ROAD SAFETY AUDIT - STAGE 1

Residential Development
At Kilbarry
Cork
June 2022

Client	Cork County GAA Board		
Project Title	Kilbarry Residential Development		
Document Title	Road Safety Audit – Stage 1		
Document No.	KBR_RSA1_D01		
Job No.	19034TT

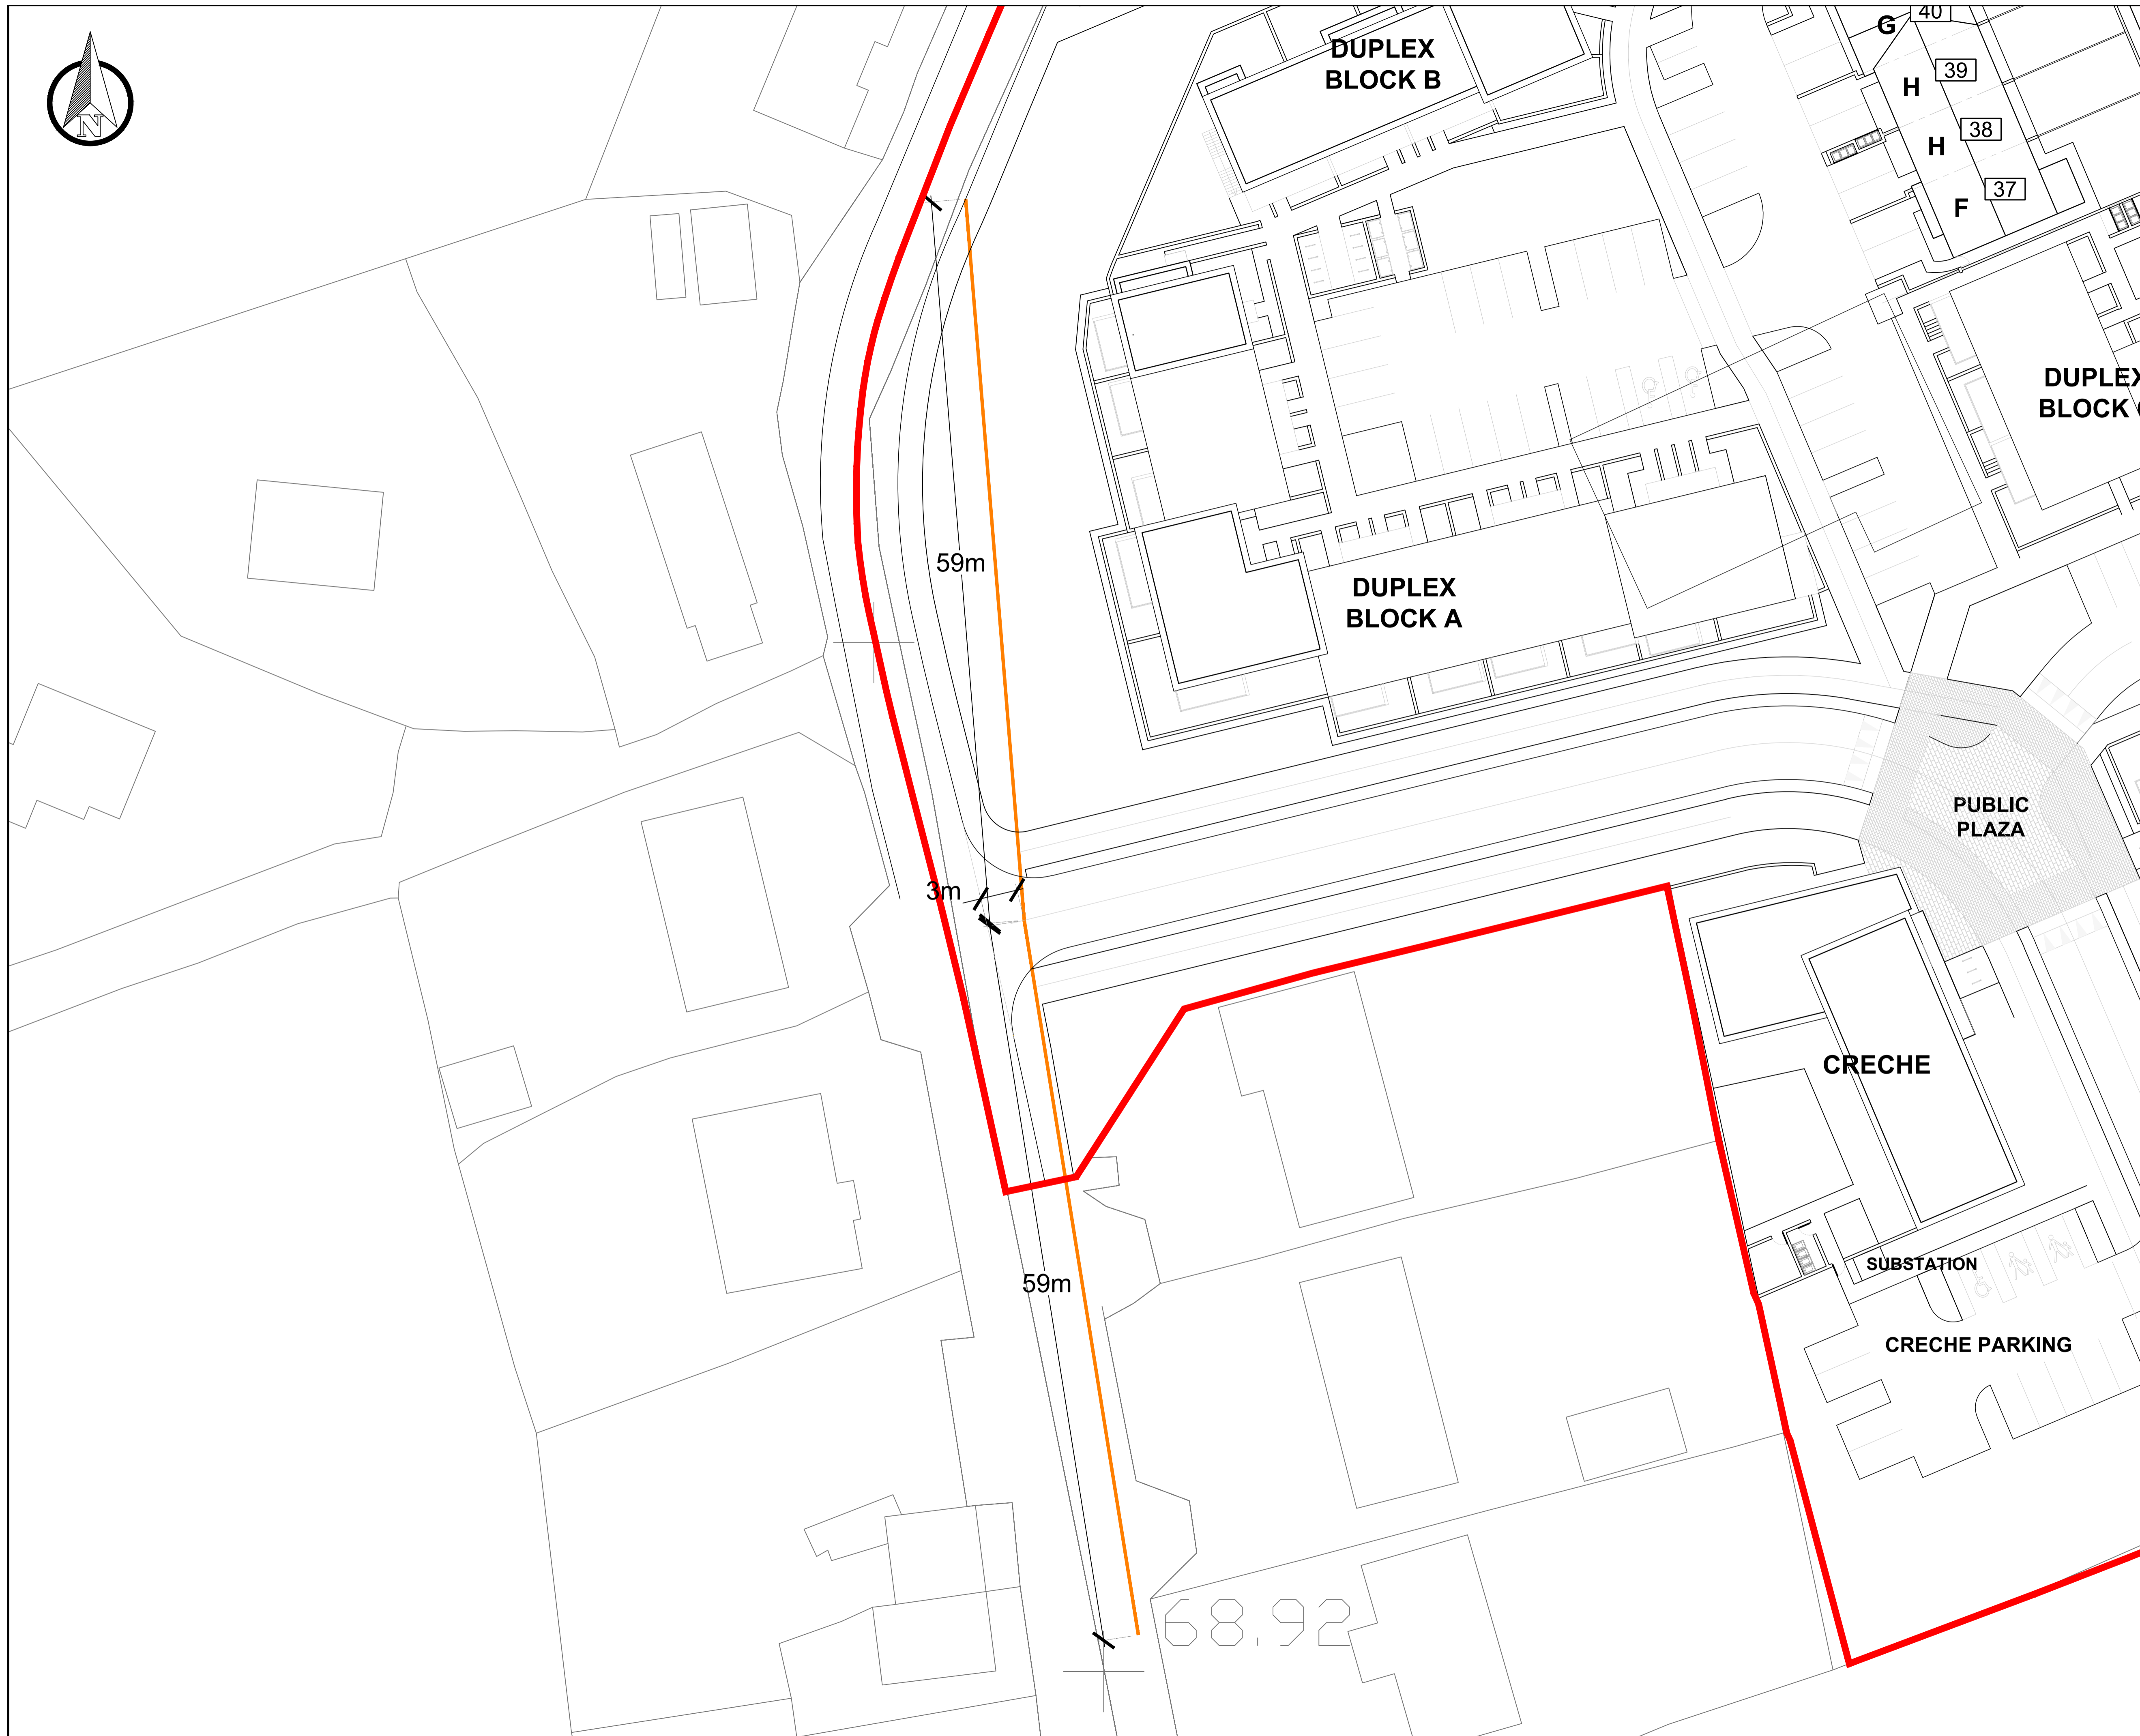
2.5 Problem: Visibility at existing junction with Upper Dublin Hill

Sight visibility to the right on exiting onto Upper Dublin Hill is partially restricted by existing fencing. Upper Dublin Hill at this location measures circa 9.0m wide which results in speeds in excess of the posted limit (observed). Restricted sightlines could result in a collision between vehicles exiting the development and mainline traffic.

2.6 Problem: Wide Entry Splays at existing junction with Upper Dublin Hill

The entry splays and junction width at the existing junction serving Delaney's GAA onto Upper Dublin Hill are excessive and allow high entry speeds when negotiating the junction. This could result in collisions between pedestrians and vehicles at this location.

Recommendation 5

In conjunction with the Local Authority the construction of a localised build-out would provide the required sightline. This would also help in reducing the excess speed observed on Upper Dublin Hill by reducing the carriageway width.

Recommendation 6

As outlined in the previous recommendation a redesign of this junction in conjunction with the Local Authority would resolve this issue.
